Mallard Pass Solar Farm

Schedule of Changes Draft Development Consent Order

Deadline 5 (5th September 2023)

EN010127/APP/9.3.5

Traffic Regulation Measures Plans - Temporary Measures

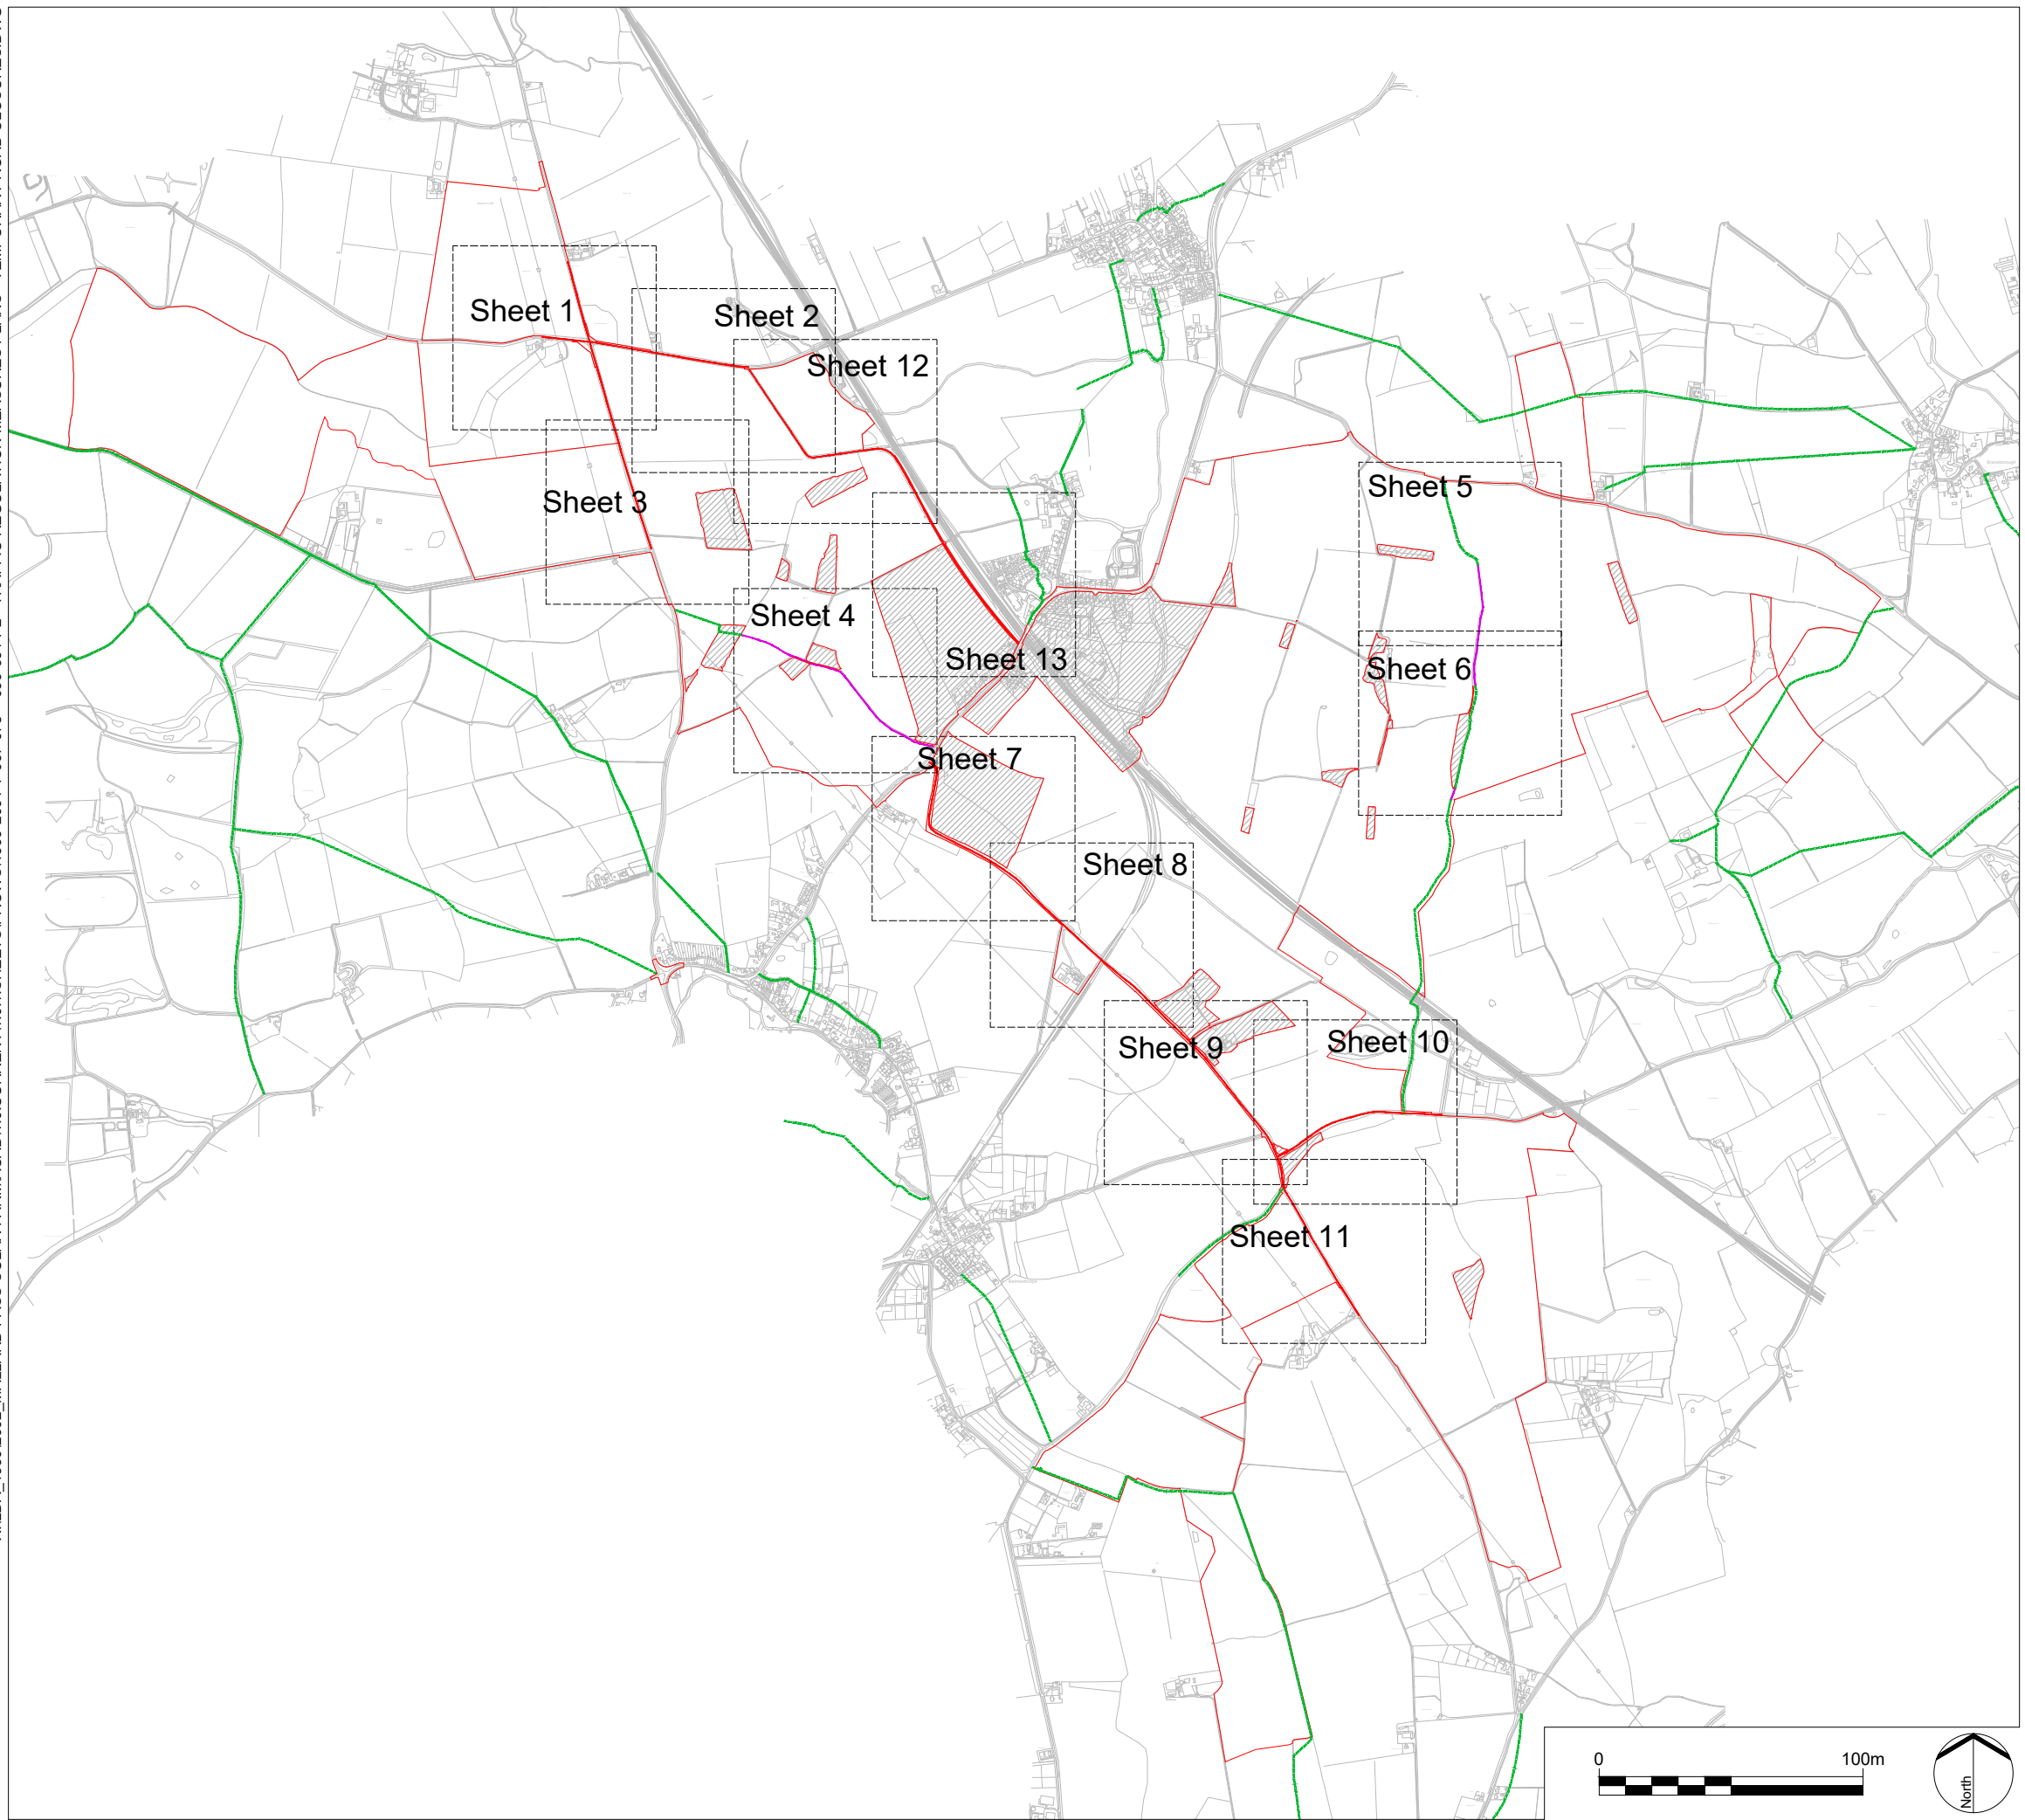
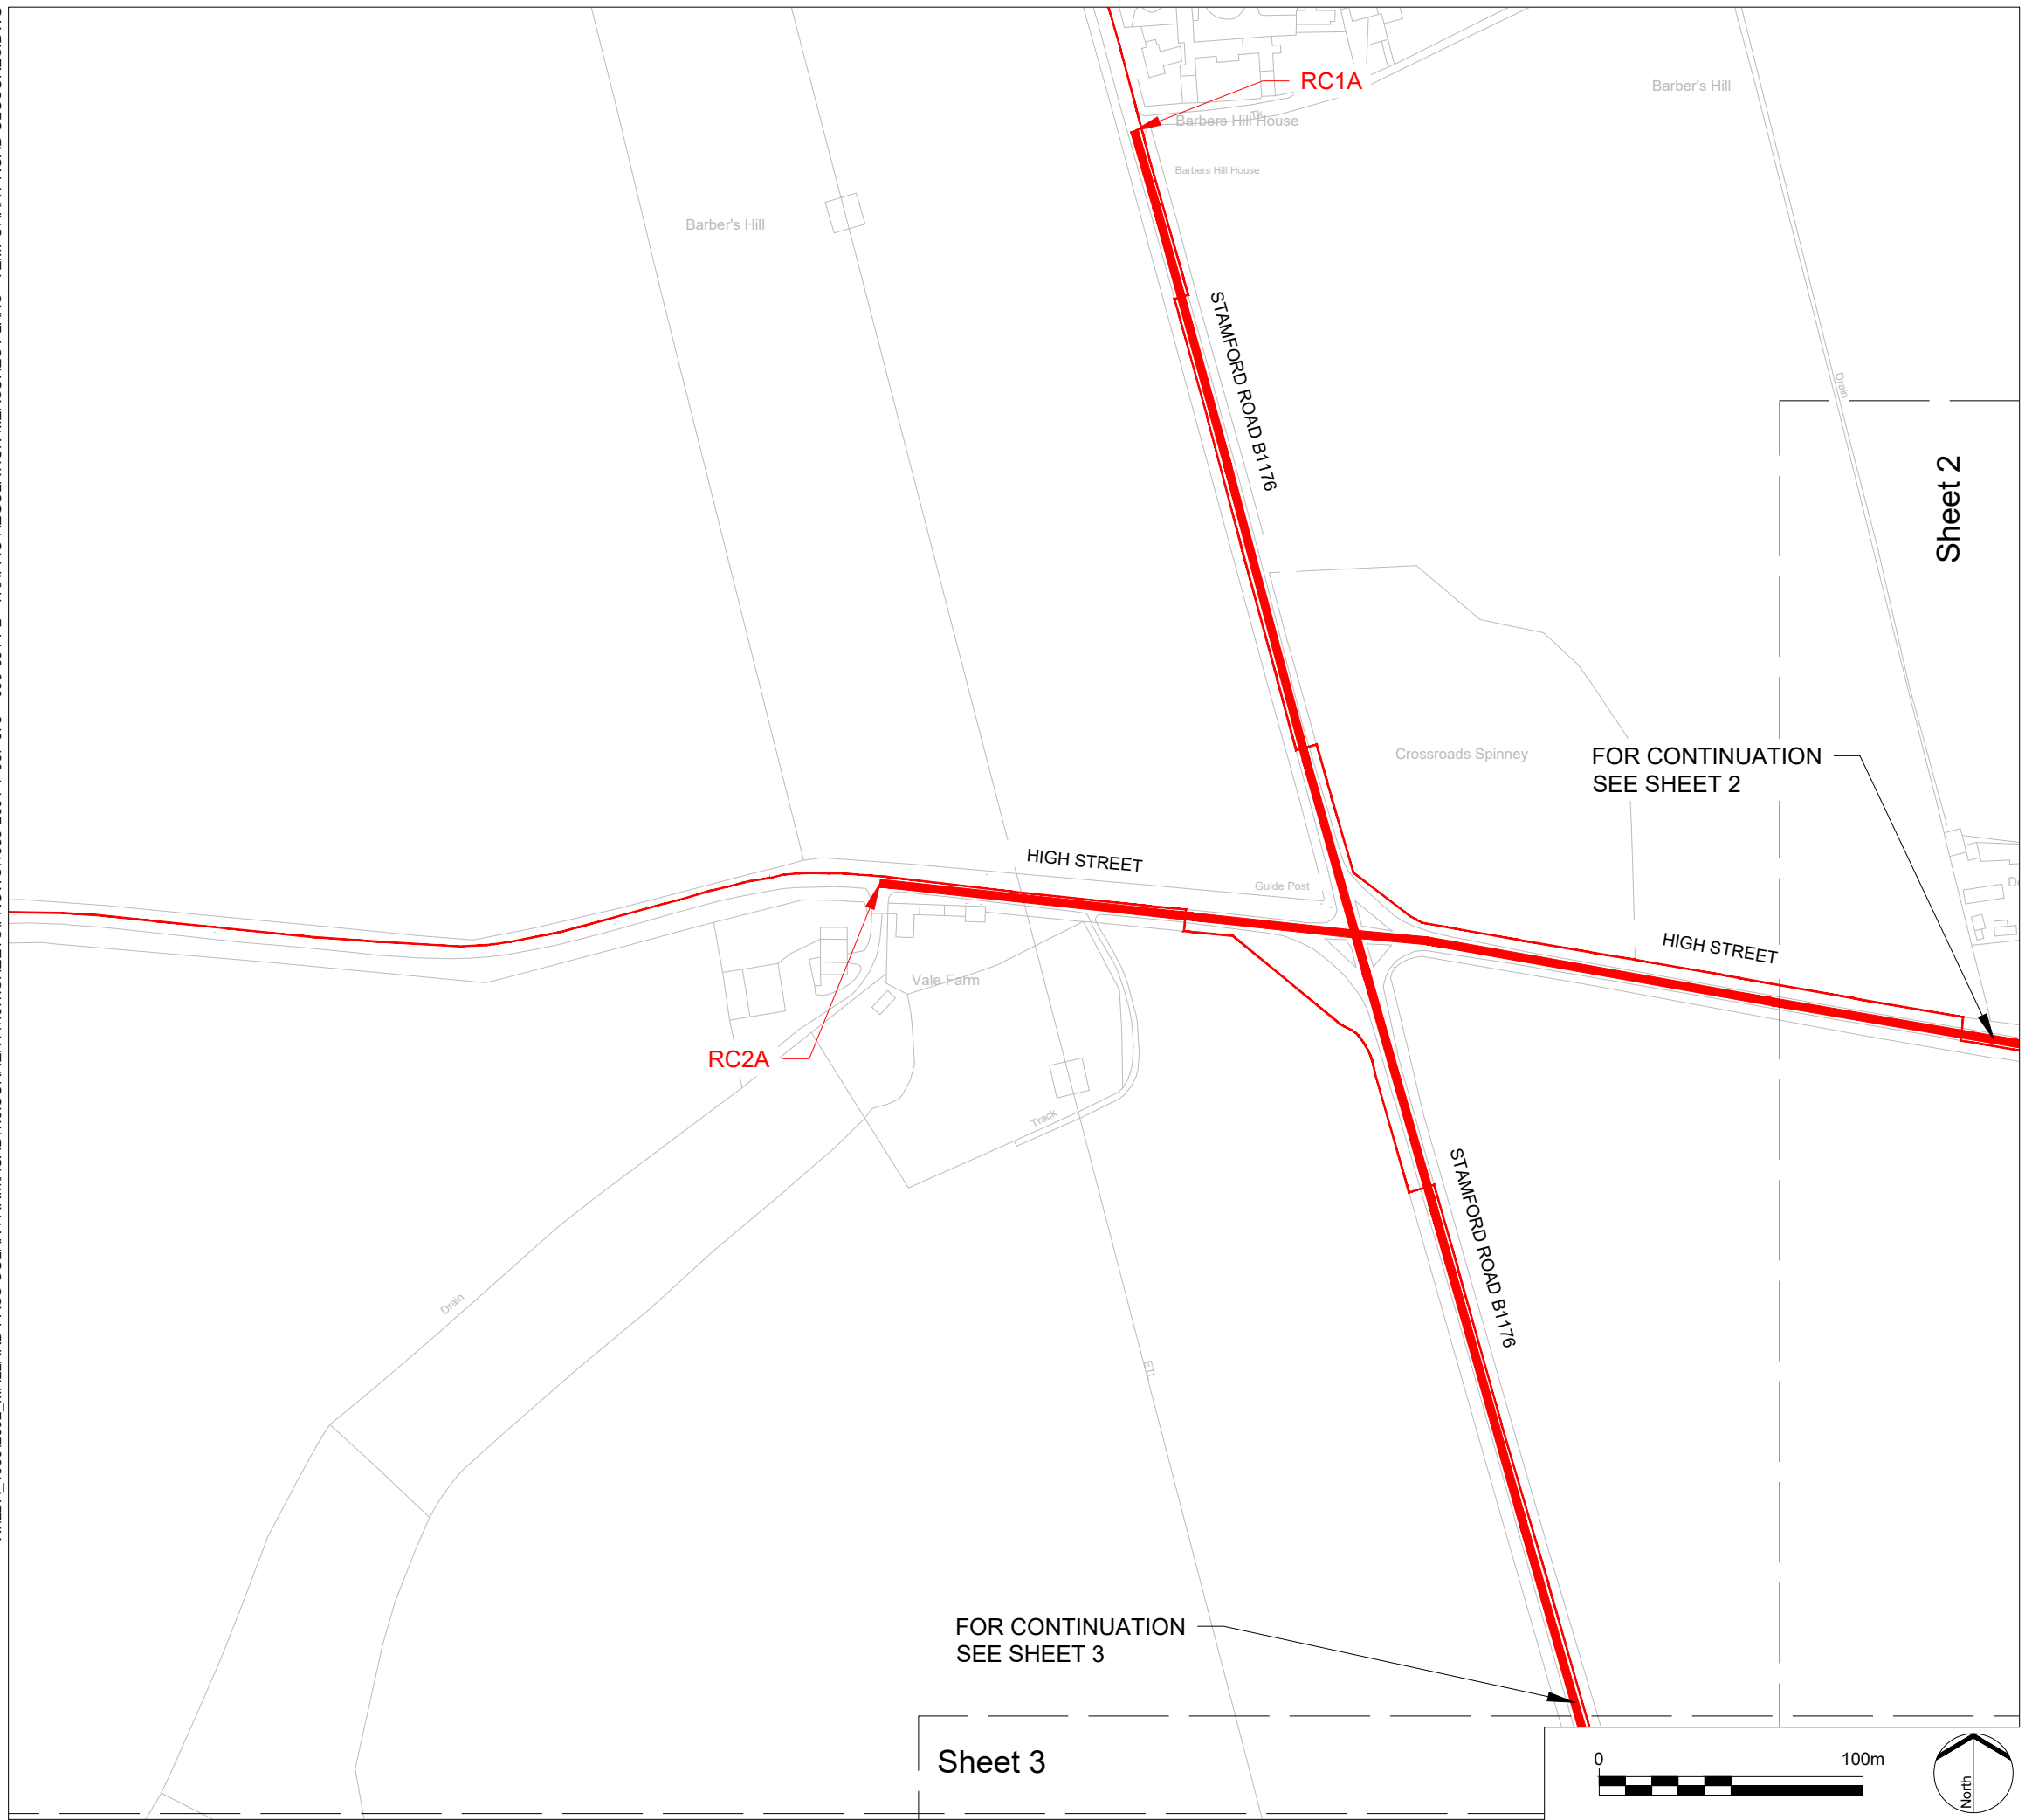
<p>draft Development Consent Order (Rev 0) to correct a typographical error.</p> <p>Other amends made to ensure Schedule is fully consistent with Access and Rights of Way Plans.</p>	
Schedule 8, Part 2	Insertion of an addition temporary road closure.	This has been inserted to reflect the updated traffic regulation measures plans – road closures (Rev 2) following comments made by MPAG at Deadline 4.	Deadline 5
Schedule 9	Amendment of definition of “vegetation maintenance rights” to include restricting or preventing the removal of vegetation.	Amended to provide further clarity on the extent of restrictive covenants sought (building on the similar drafting in the other 'categories' of rights in this Schedule) pursuant to article 22(2) following the ExA's Second Written Question 5.0.6.	Deadline 5
Schedule 4, 5, 6, 7, 8	Amendment from 'District' to 'Area'	Amended following the ExA's Second Written Question 5.3.1	Deadline 5
